Application No: EP/163/21/HH
Site Address: 4 Selhurst Close East Preston BN16 2SR
Description of works: Single storey front extension, conversion of integral garage and new detached garage.

Thank you for your internet representation made on 14th January 2022 which has been recorded as an objection with the comments as follows:

Proposed
Elevations
1:100

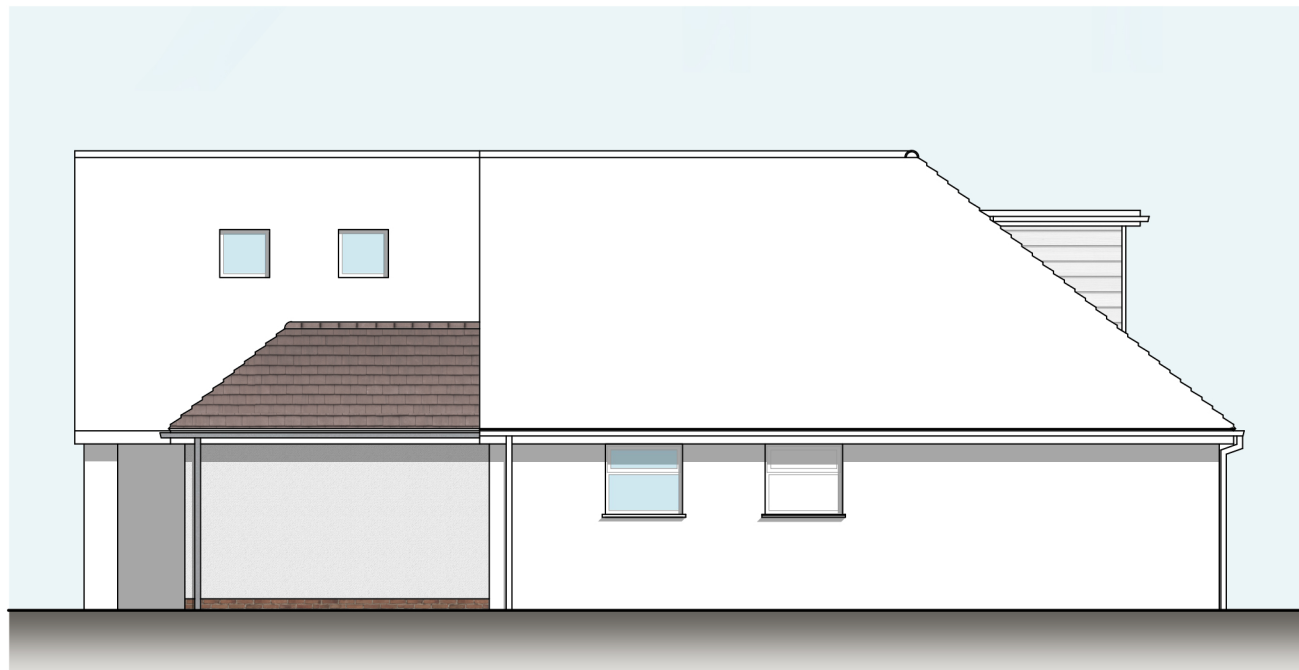
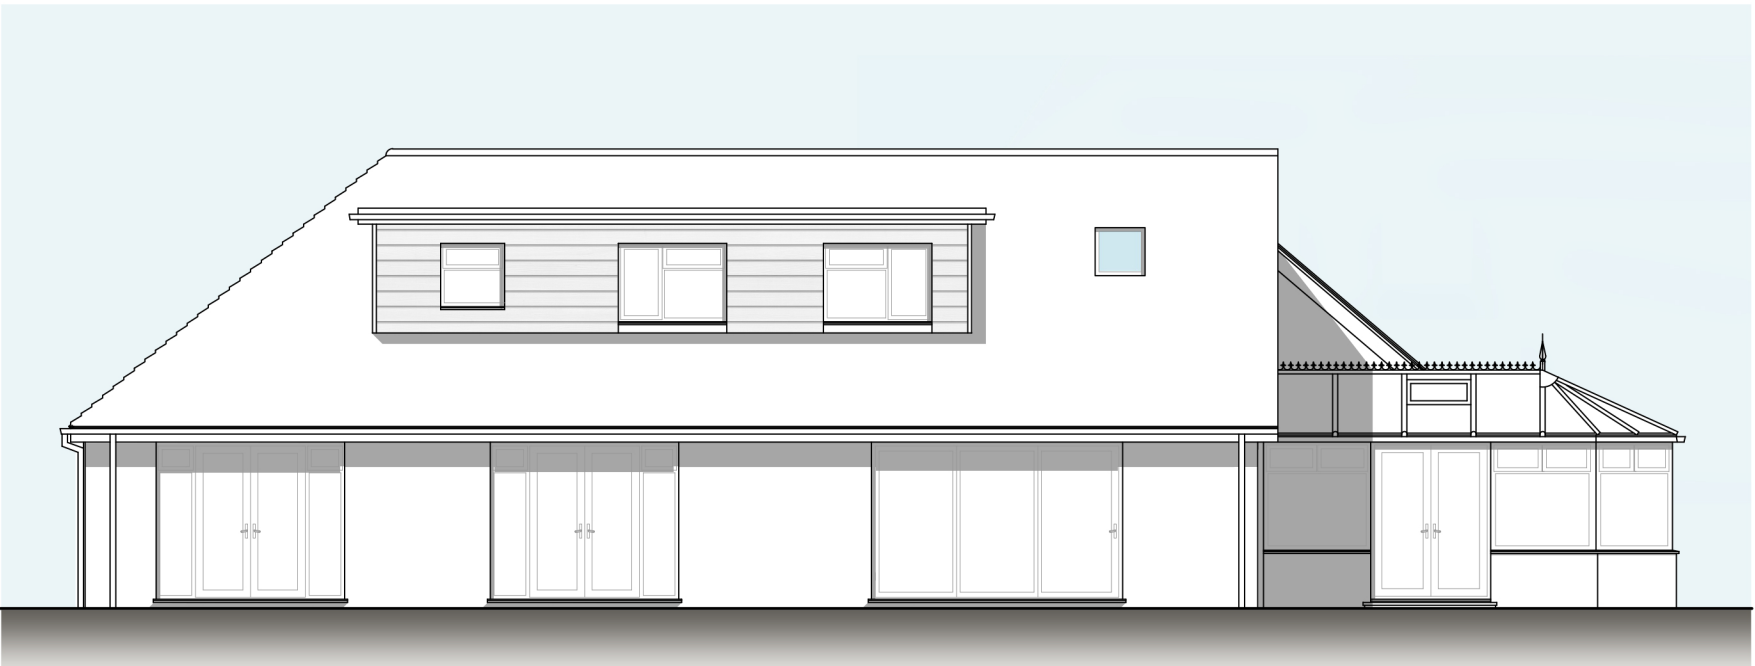
I write as Chairman of the East Preston and Kingston Preservation Society. The extensions and garage proposed for this plot would present a cramped appearance in an area characterized by spacious development. The northern corner of the ground floor extension would be close to the boundary with number 5 Selhurst Close. The impact of this would be aggravated by the necessity of removing a mature hedge along the northern boundary. The position of the garage so far forward of the house is another aspect of the design that would compromise the relationship of structures on this plot with other properties in Selhurst Close. This is exacerbated by the height of the garage (3.745m). The Society asks that this application be refused for all the above reasons.
